Engineers Comments Regarding Surface Water Drainage

Application Reference:	Y/27/26/HH	Reviewer Reference:	ADC/KW/PC
Planning Officer:	Susan Haley	Date of Review:	22/07/2026
Site Name:	North Barn, Hoe Lane, PO22 8NT		
Application Description:	Retrospective front porch.		
Assessment Number:	1 of 1

NORTH BARN – BRIEF DRAINAGE STATEMENT

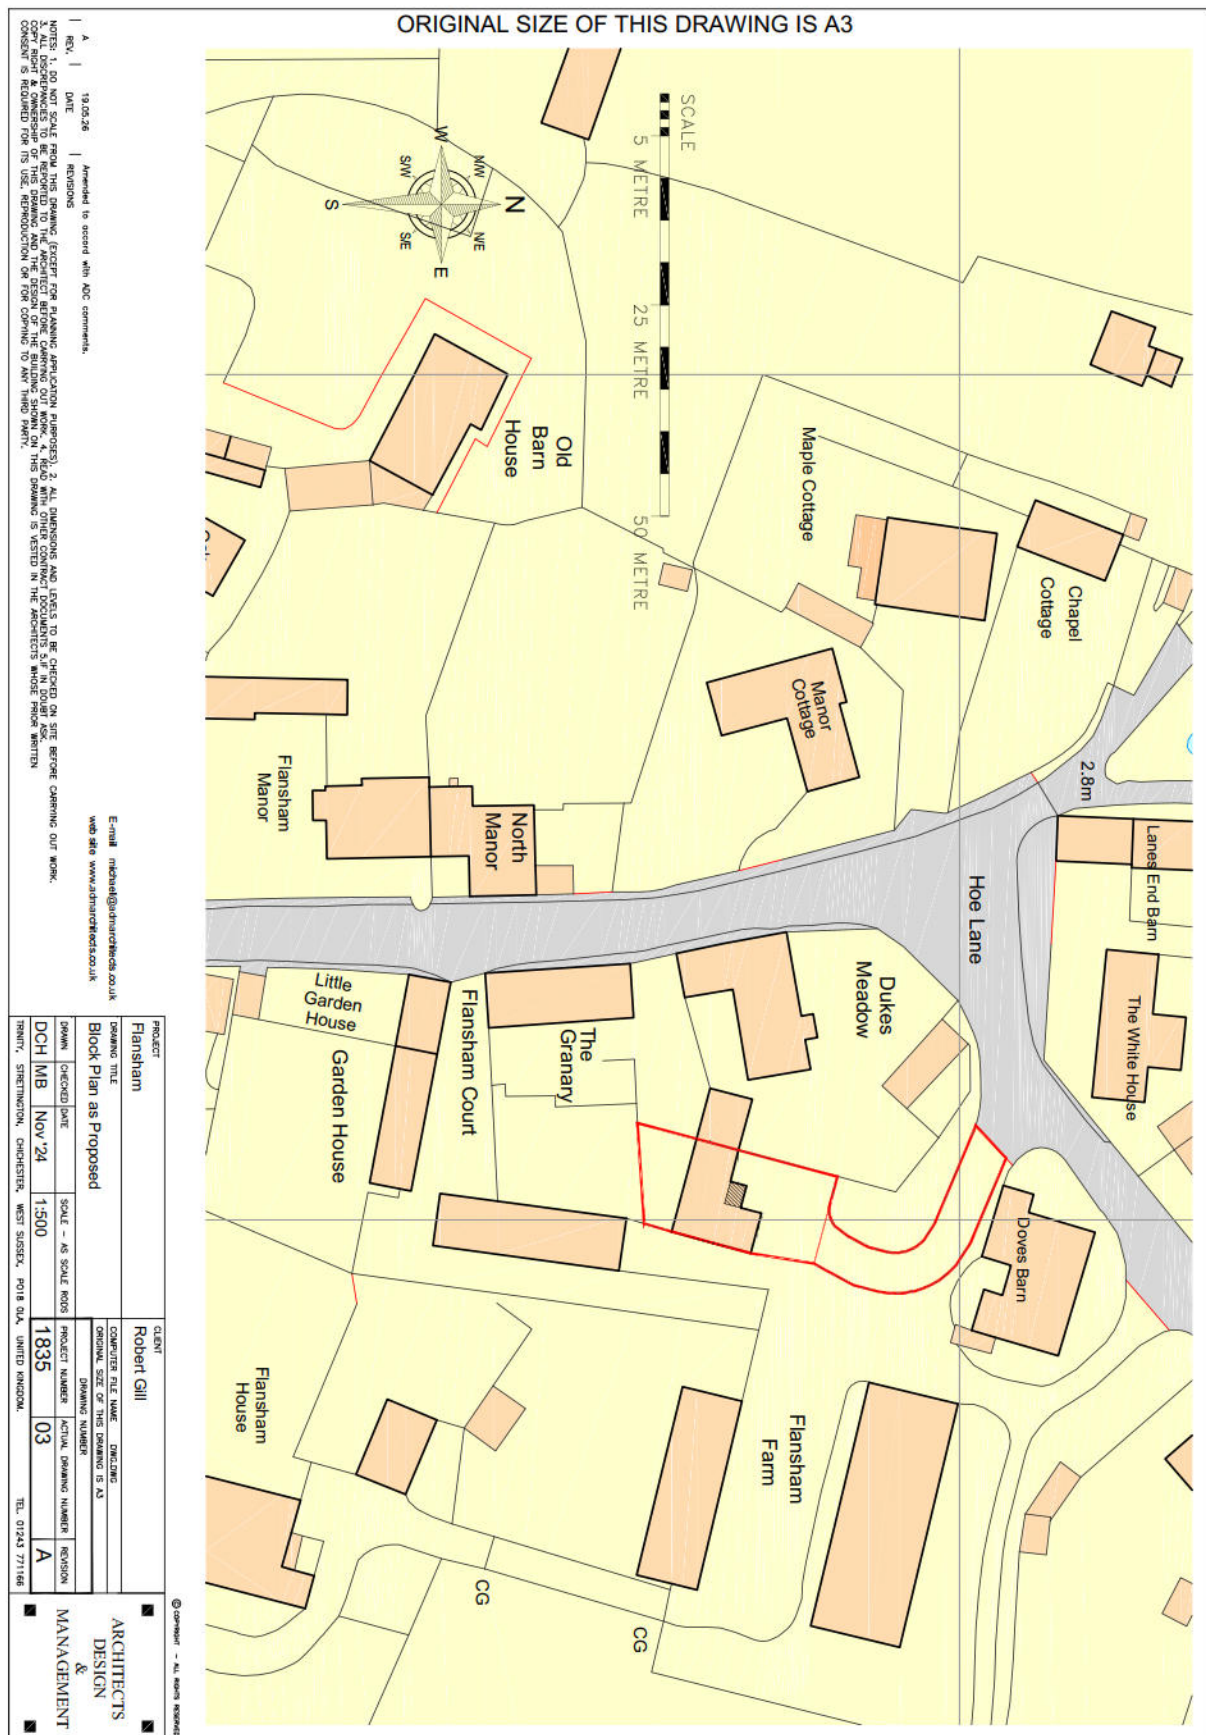
1.1. This is a retrospective application. It is stated that surface water drainage from the proposed porch connects to the existing drainage system approved under application reference Y/60/23/DOC. A review of the approved drainage layout indicates that the final point of discharge is a surface water drain.

1.2. In these circumstances, it would be expected that the applicant or their agent provide supporting commentary and any available historical site information to demonstrate that the existing drainage

arrangement accords with the drainage hierarchy and meets the relevant design and performance standards. No such information has been submitted in support of this application.

- 1.3. Furthermore, the application documents do not clearly identify the final discharge location. In the absence of sufficient evidence to demonstrate compliance with the drainage hierarchy and the required standards, the proposal is considered to be contrary to Standard 1 of the NSfS.

- 1.4. The applicant has not provided sufficient evidence of the details or condition of the existing system, nor demonstrated that, it has the hydraulic capacity to satisfactorily drain surface water in accordance with current standards.

- 1.6. Winter groundwater monitoring and infiltration testing should be re-submitted to evidence that infiltration, the highest priority discharge location has been correctly discounted. Furthermore, water re-use (which would not provide a full design solution) should be included within the design.

2.1. No interception features have been provided, as such the proposal does not accord with Standard 2 of the NSfS. In recognition that the National Planning Policy Framework states that SuDS should be proportionate to the nature and scale of the proposal we are willing to accept that the following interception features can demonstrate compliance without further detailed assessment.

2.2. As infiltration is unlikely to be viable these features may affect the scale or layout of development and as such **we object** on these grounds.

3.2. At present, no modelling or supporting evidence; such as ground investigations or drainage plans have been submitted for engineering assessment. In the absence this evidence, we cannot assess if flood risk will be increased by the surface water drainage of the proposed development. Therefore, this application does not accord with the NPPF as set out above and **we object** on this basis.
